# CITY OF ALBUQUERQUE

**Re: Zepol Complex @ Journal Center II, 7421 Bartlett St. NE,**  
**Request for Permanent C.O. - Approved**  
**Engineer's Stamp dated: 06-15-09 (D-17/D101)**  
**Certification dated: 10-25-11**

**Re: Zepol Complex @ Journal Center 2, 7421 Bartlett Street NE,  
Request for C.O.—90 Day Temporary Approved  
Engineer's Stamp dated: 06/15/09 (D-17/D101)  
Certification dated: 10-25-11**

**Re: Zepol Complex at Journal Center 2 Grading and Drainage Plan**  
**Engineer's Stamp date 4-28-09 (D17/D101)**

GRADING AND DRAINAGE PLAN

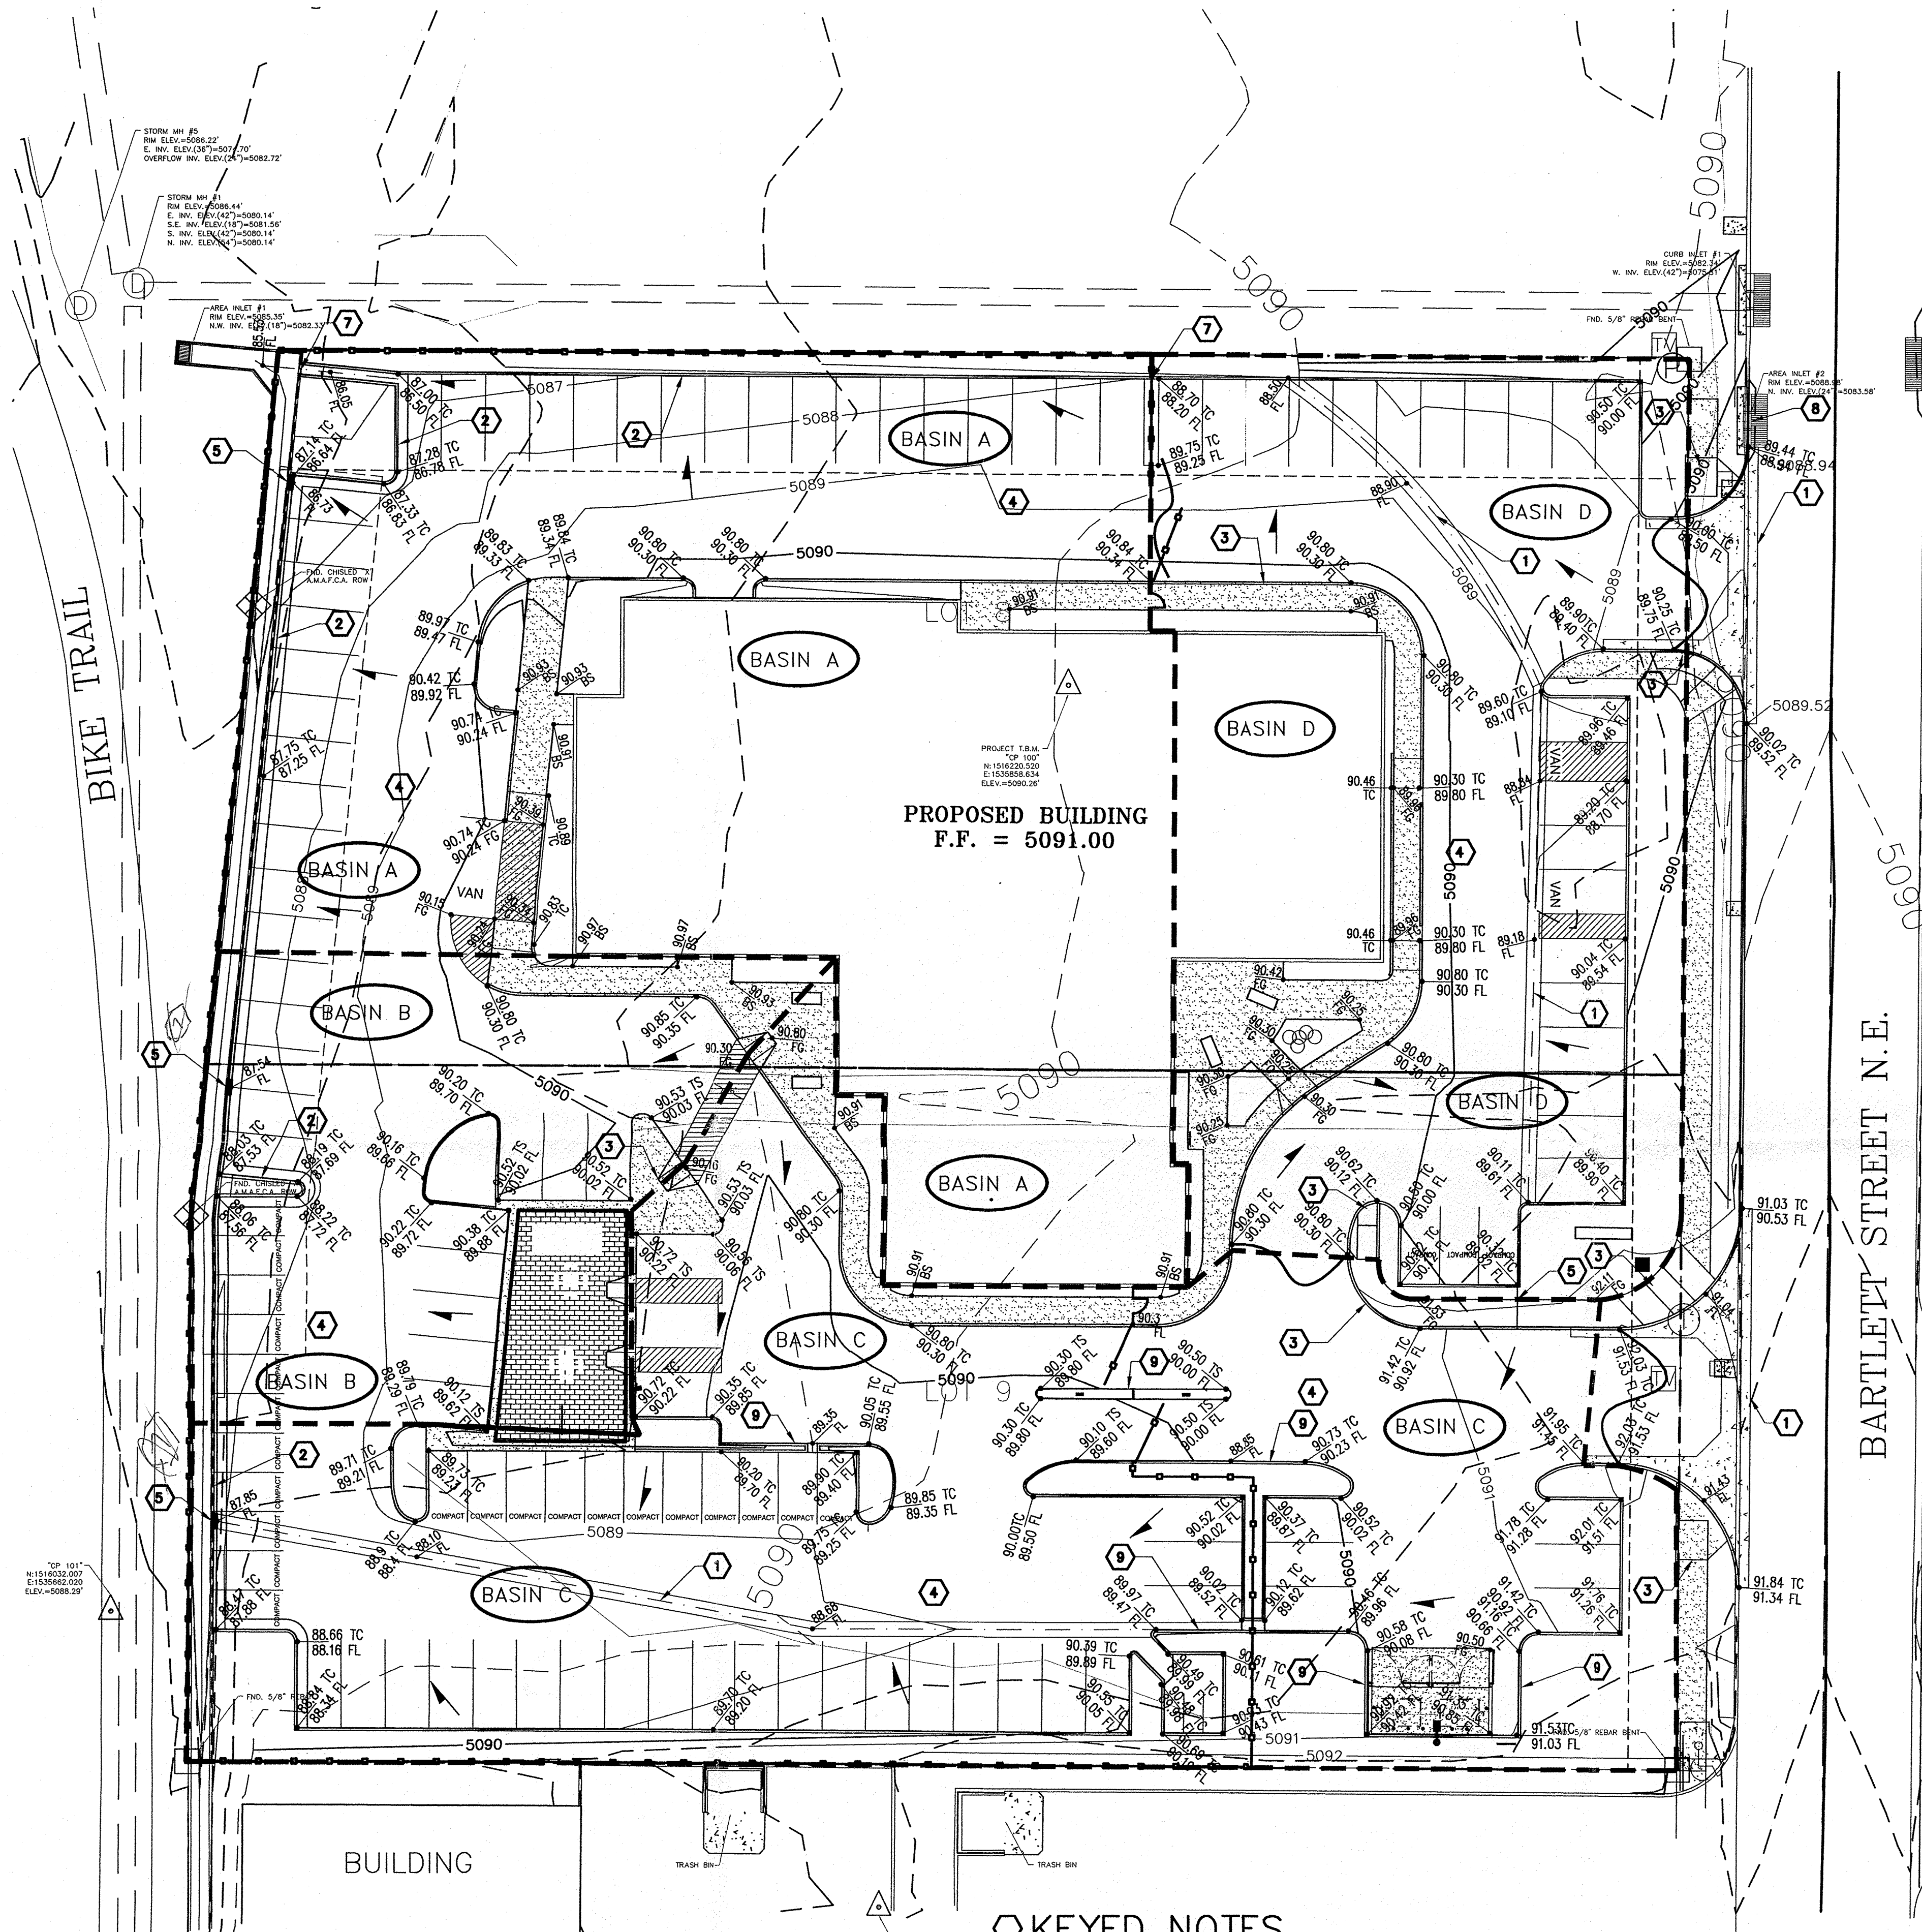
- The channel and inlet on the west property line will need cleaning. Remove all construction debris and sediment that has accumulated during construction activity.

AAMAFCA STORM WATER TRASH SCREEN

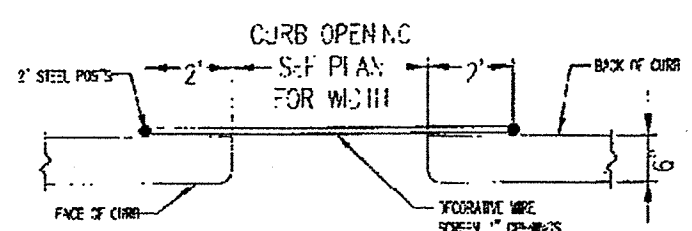
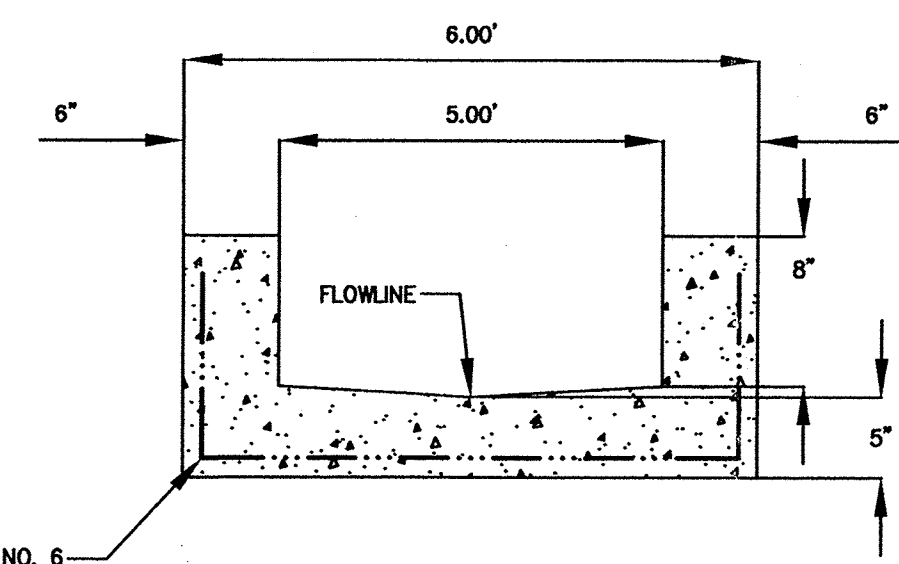
- AMAFCA is requiring a storm water quality debris screen. AMAFCA can provide a detail.
- The refuse enclosure was relocated on the Site Plan.
- An approved Site Plan is required.
- There is a Keyed Note 2 to build curb and gutter across the north entrance.
